Our Case Number: ABP-314724-22

Re: Railway (Metrolink - Estuary to Charlemont via Dublin Airport) Order [2022]
Metrolink. Estuary through Swords, Dublin Airport, Ballymun, Glasnevin and City Centre to
Charlemont, Co. Dublin

Name : Amanda Hughes**Address: 9 Berkeley Road , Phibsborough, Dublin 7 D07 W6T8****Observation Reference :****Railway Order 2022 (Metrolink-Estuary to Charlemont via Dublin Airport)****Mater Stop**

Mater Stop station Design:

MATER STATION

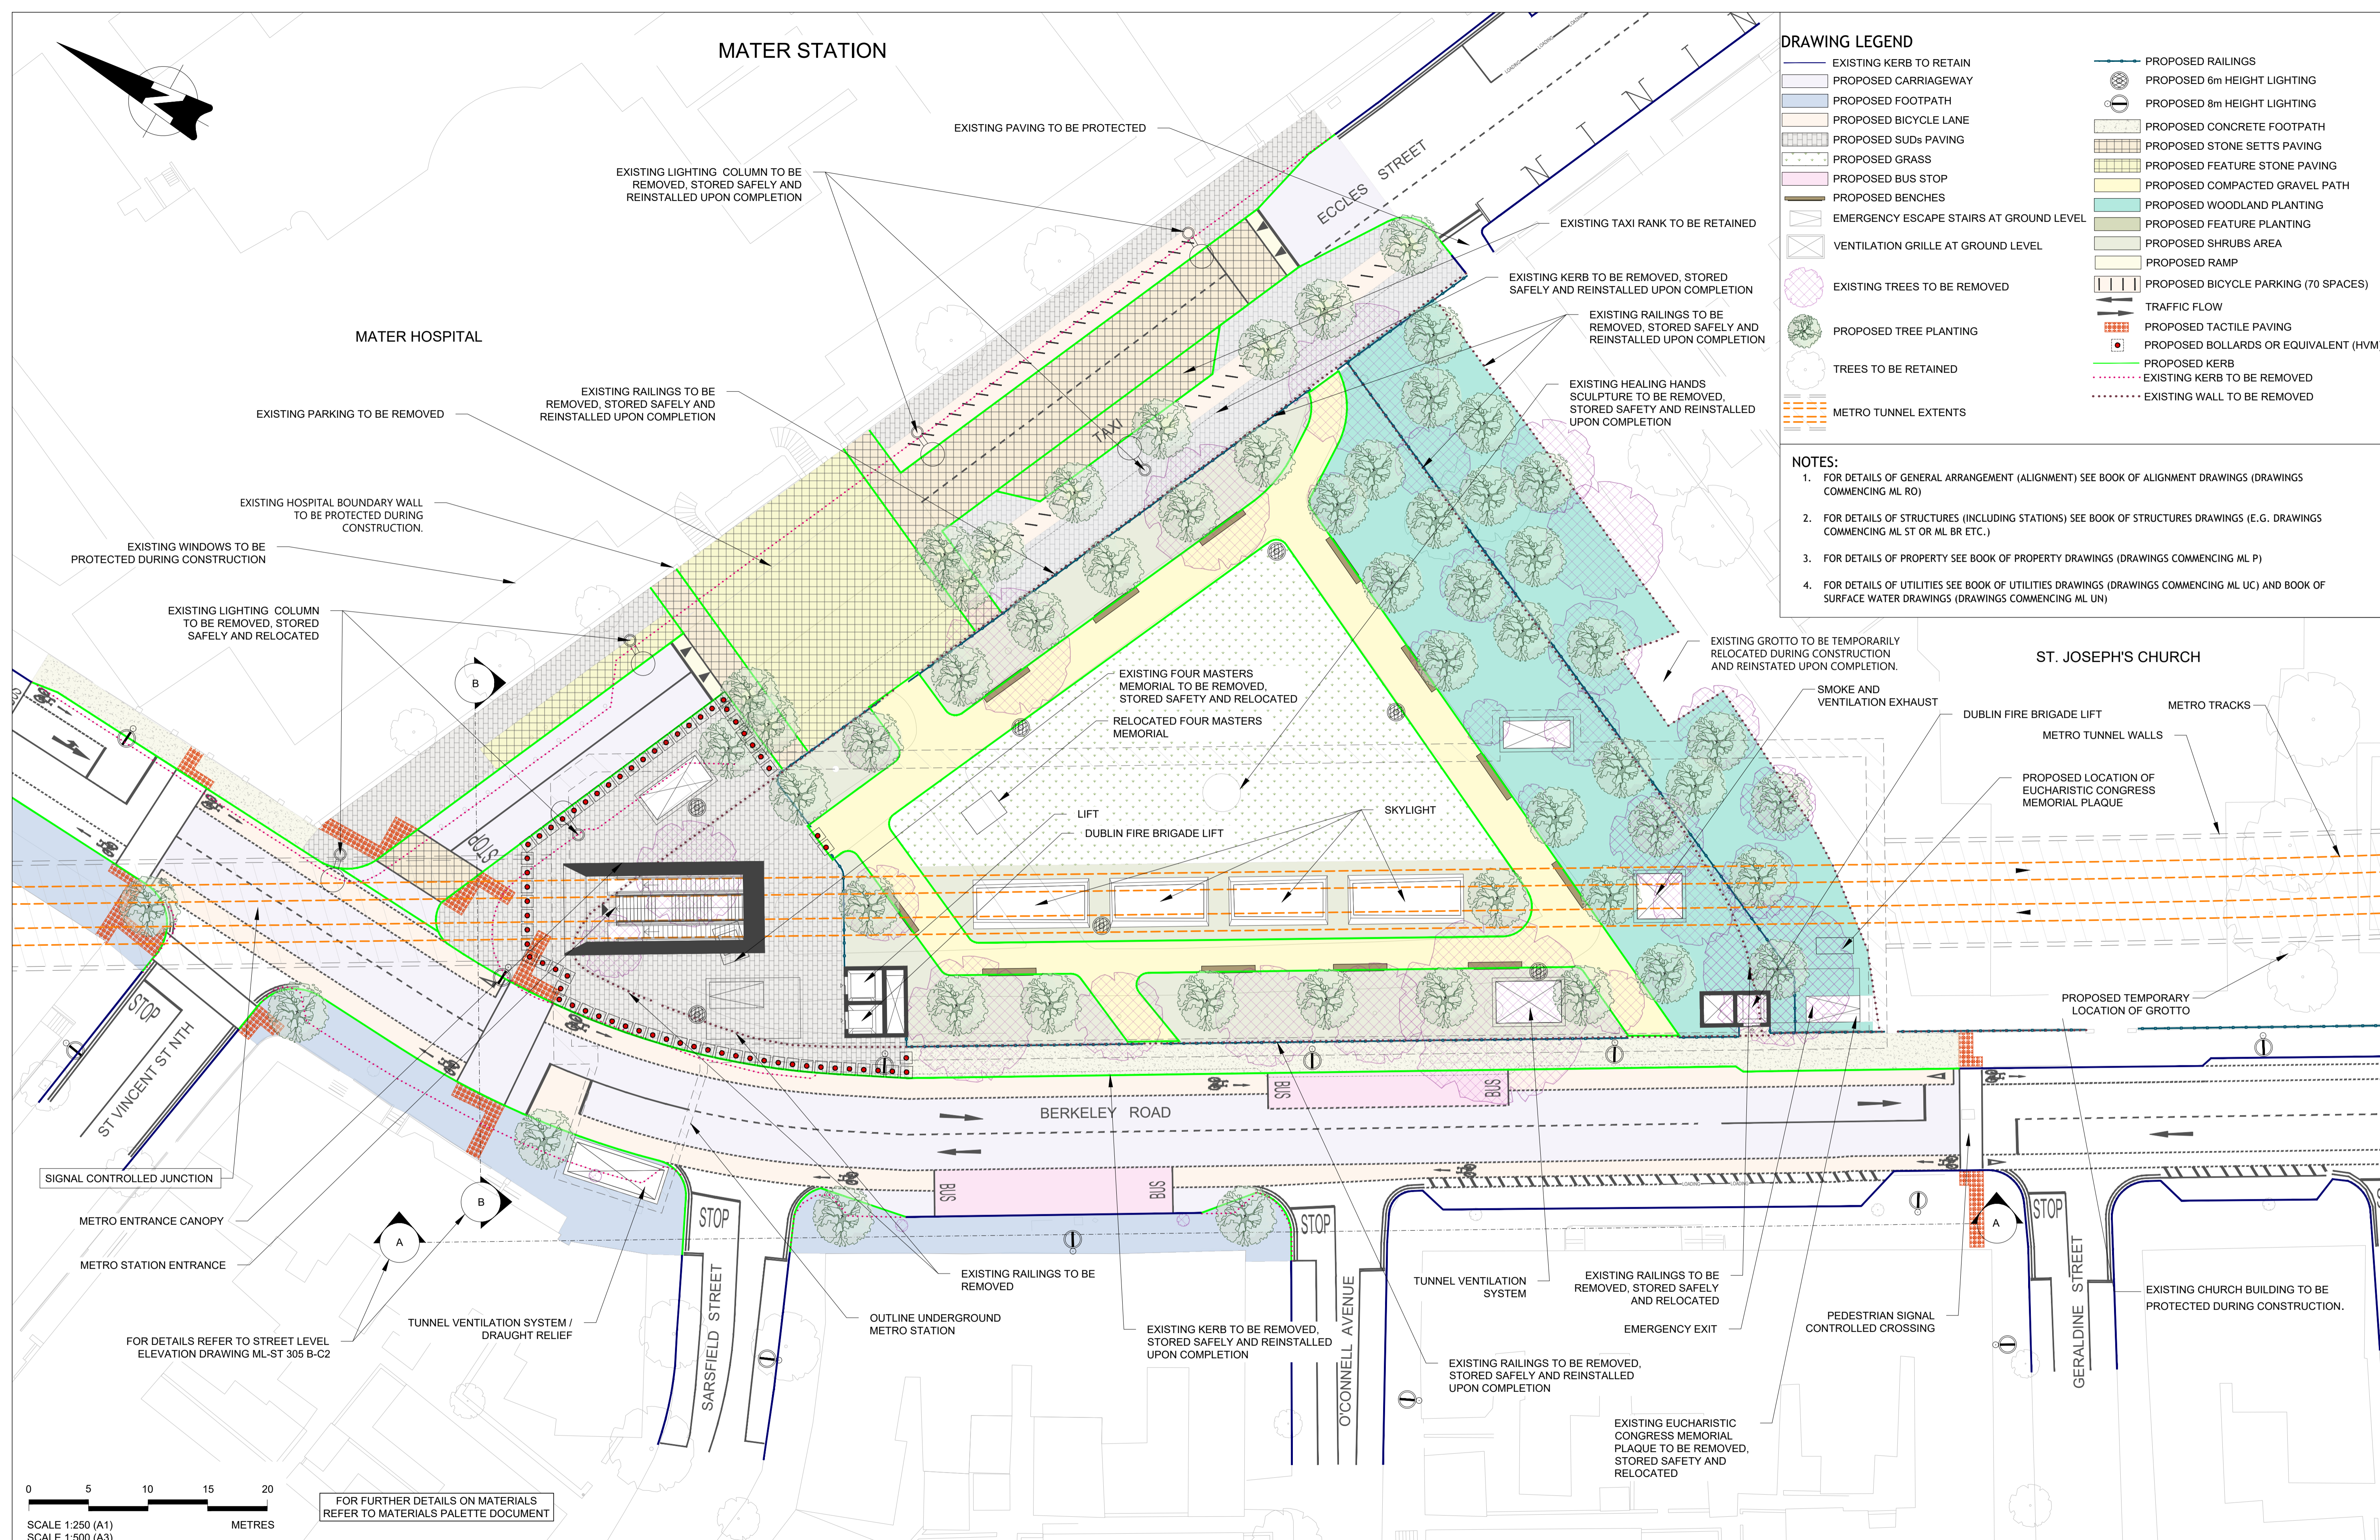
I am extremely concerned about the design and location for the Mater Stop and the ancillary structures. The correct design for the area will enhance rejuvenation and positive redevelopment after the 9 years of construction whereas an unattractive utilitarian design approach to the station and The Four Masters Park may have a very adverse effect on an area that has huge potential for being a really positive asset in the North Inner City and Phibsborough village . To compliment the location I feel that the canopy of this station should have less footprint , elevation and visual impact .

The view of the Mater Hospital building will be blocked from Berkeley Road. With either a different canopy design or using a different location in Four Masters Park would have a very positive effect on the commercial potential for Berkeley Road. The ancillary buildings (lifts, emergency exit , ventilation shafts, lights) further block the view into the park visually shutting the off the park from Berkeley Road and diminishing any sense of space in the street.

The hard materials of the unnecessarily wide plaza which skirts the station in its current design location is inappropriate as it is too big and visually competes with the Mater Hospital steps there is a risk that this type of wide and inappropriate space may invite anti-social behaviour and loitering. The bollards could be replaced with planters as seen on Grafton St.

relocating the station entrance to face the side walls of St Joseph's church on Berkeley Road would allow for the entrance / exit to be onto Eccles St. This location provide a more visually and softer view of the station entrance because it could be surrounded by trees as in the Stephens Green montage, it would also allow for the relocation of the ventilation shafts, lifts and emergency exit to be relocated resulting in the opening up the vista of the Four Masters Park, and the Mater Hospital.

Locating the station entrance further into the park near St Joseph's church would be safer for station users to enter and exit the station. In its proposed current location there is a great risk of pedestrians running across roads to the station as the proposed entrance is located very close to a cross roads (Berkeley Road, Eccles St and Vincents St) . there is a proposal to pedestrianise Eccles St which will make it a safer entranc. It will also be safer to have the emergency exit located on the Eccles St side of the park rather than beside Berkeley Road which is a busy road at peak times

ELEVATION A - A

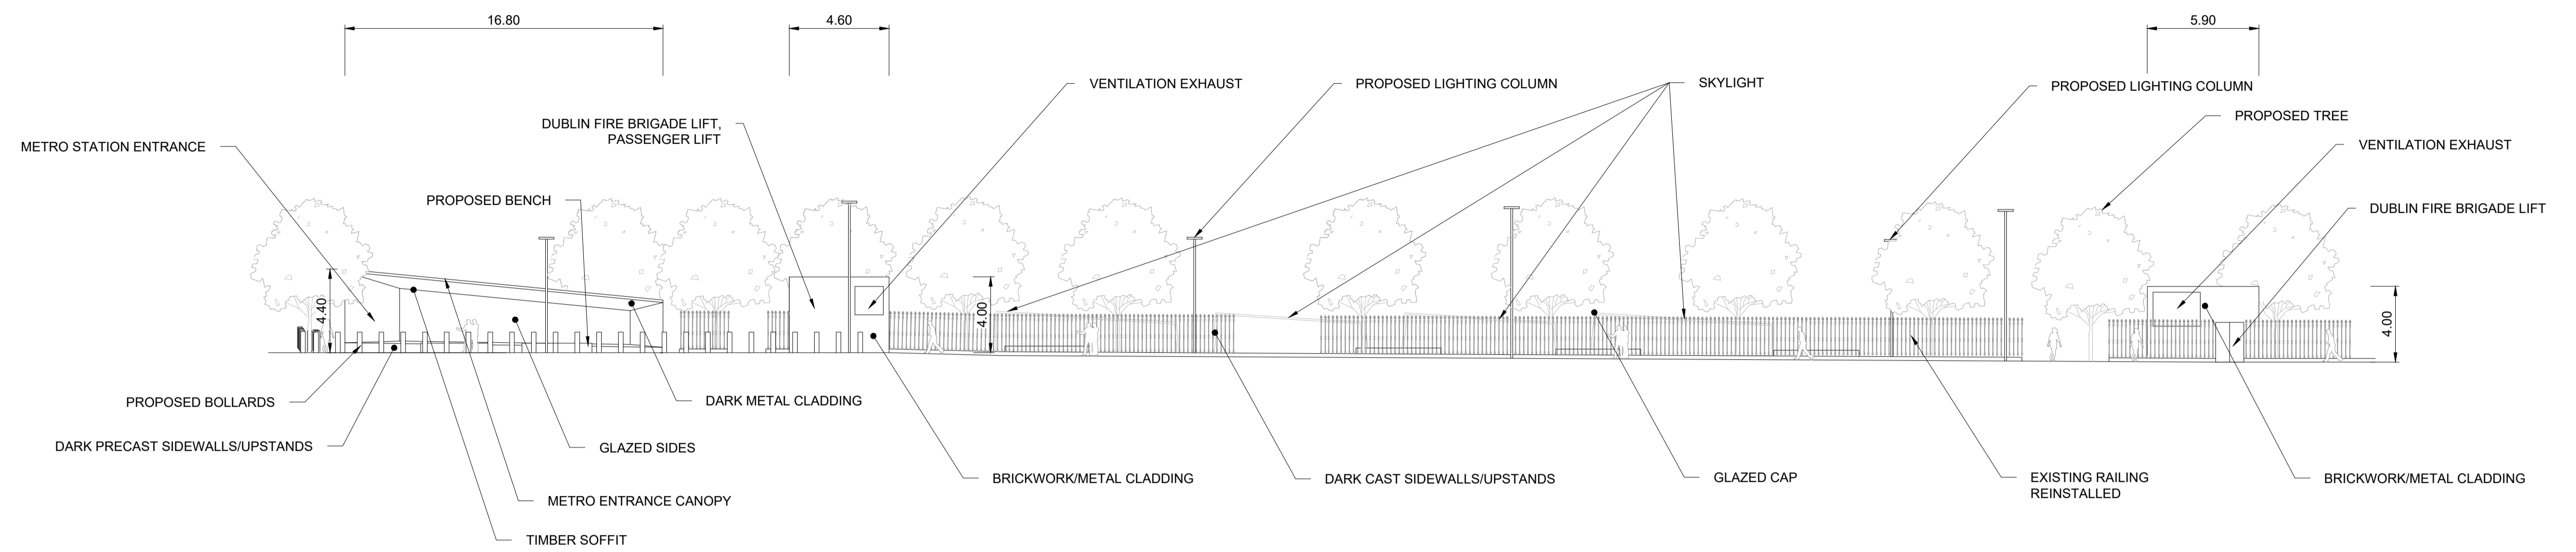
These are inappropriate for this location, it is an architecturally sensitive area and zoned under Objective Z2 in the Dublin City Development Plan 2022-2028. The buildings on Berkeley Road and street are Victorian and made of red brick, while the Mater Hospital and St Joseph's church are made of granite, the proposed Mater stop station is a glass structure with heavy looking brown detailing , the emergency exit is of brown brick and resembles a public toilet .
